Laurclavagh Renewable Energy Development Response to ACP FI reply from MKPO, Galway

Planning Reference: 319307

Date for Submission: 9th January 2026

Response to Further Information Laurclavagh Renewable Energy Development

Figure FI 1 N83 / L61461 / L61461 junction with STOP line located at carriageway edge

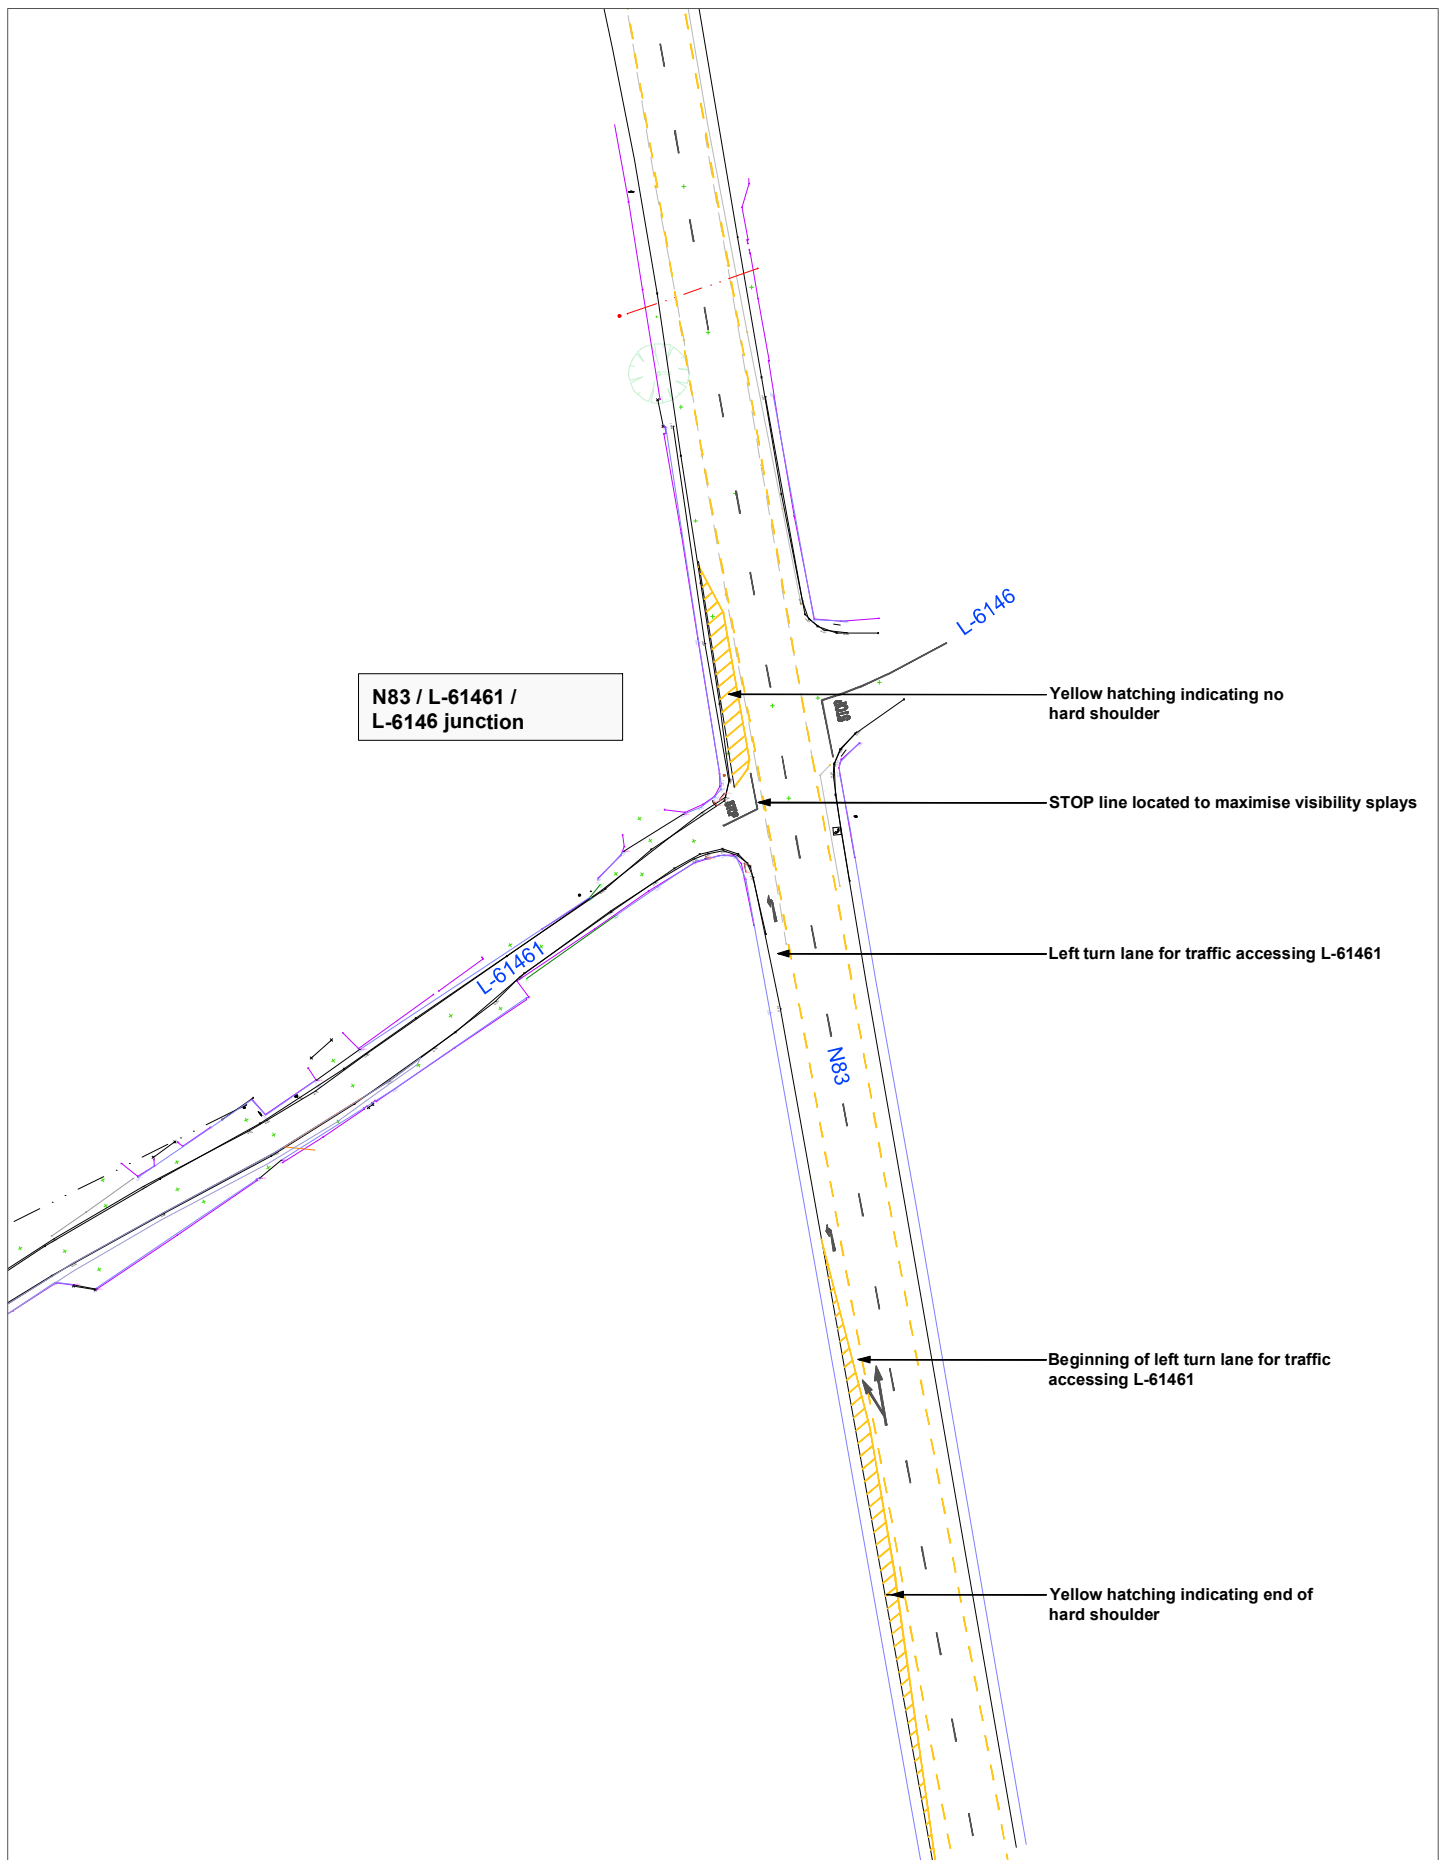
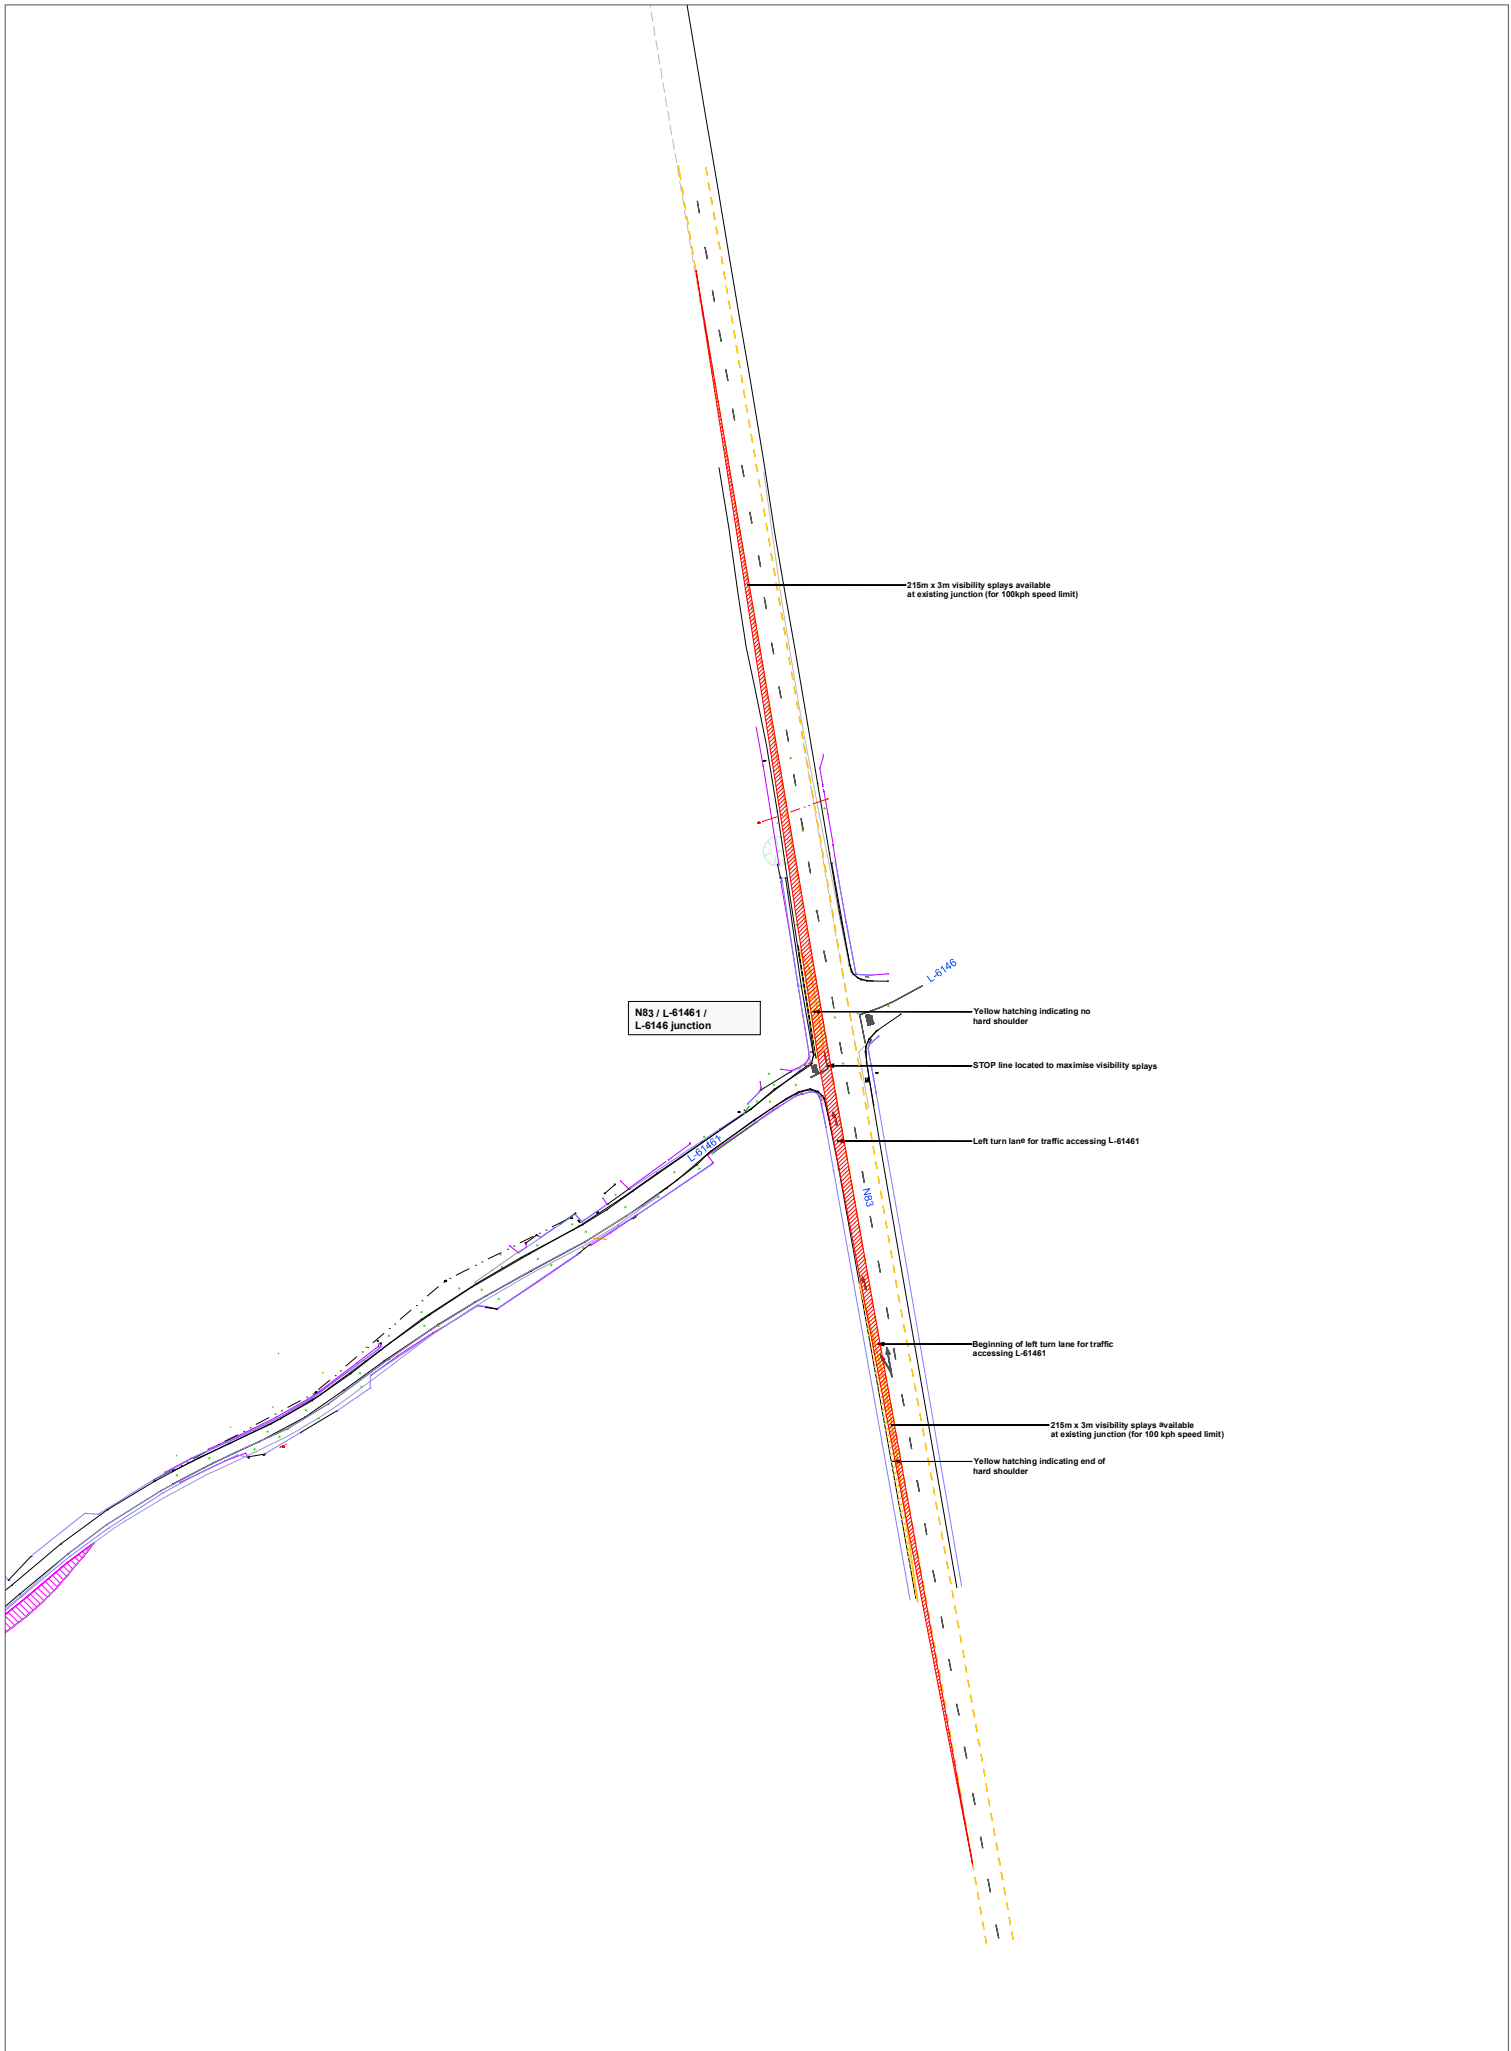
This layout does not comply with TII Standards

This is not correct. The minimum X distance requirement is 3m. If a relaxation was envisaged, the applicant should have requested it from TII & provided evidence of their approval, but didn't do so. The Y distance should be a minimum 213m & not 35/20m.

Applicants Response – The 2 different junction layouts are discussed in detail in the Responses to ABP Issues Report, including Figures FI1 to FI4 in Appendix 15-5 of the Report. In summary the previous layout at the N83 / L-61461 junction included the STOP line of the minor arm of the junction being located adjacent to the carriageway edge, as opposed to the nearside edge of the hard shoulder, which permitted the full 3.0m x 215m visibility splays required for a 100 kph speed limit to be available. The junction layout has since been revised to include the relocation of the STOP line to be in line with the nearside of the hard shoulder. The recently implemented changes to the junction markings have been implemented without any alterations to the boundary walls running parallel to the N83, and as a result, there are significant restrictions to the visibility splays for drivers accessing the N83 from the L61461, as are shown in Figure FI4 of the in Appendix 15-5 of the Report. **Measured from a minimum setback of 2.4m as permitted as a relaxation in TII Guidelines, as a result of the boundary walls now constraining visibility splays, a maximum of 35m is available to the north, and 20m to the south.**
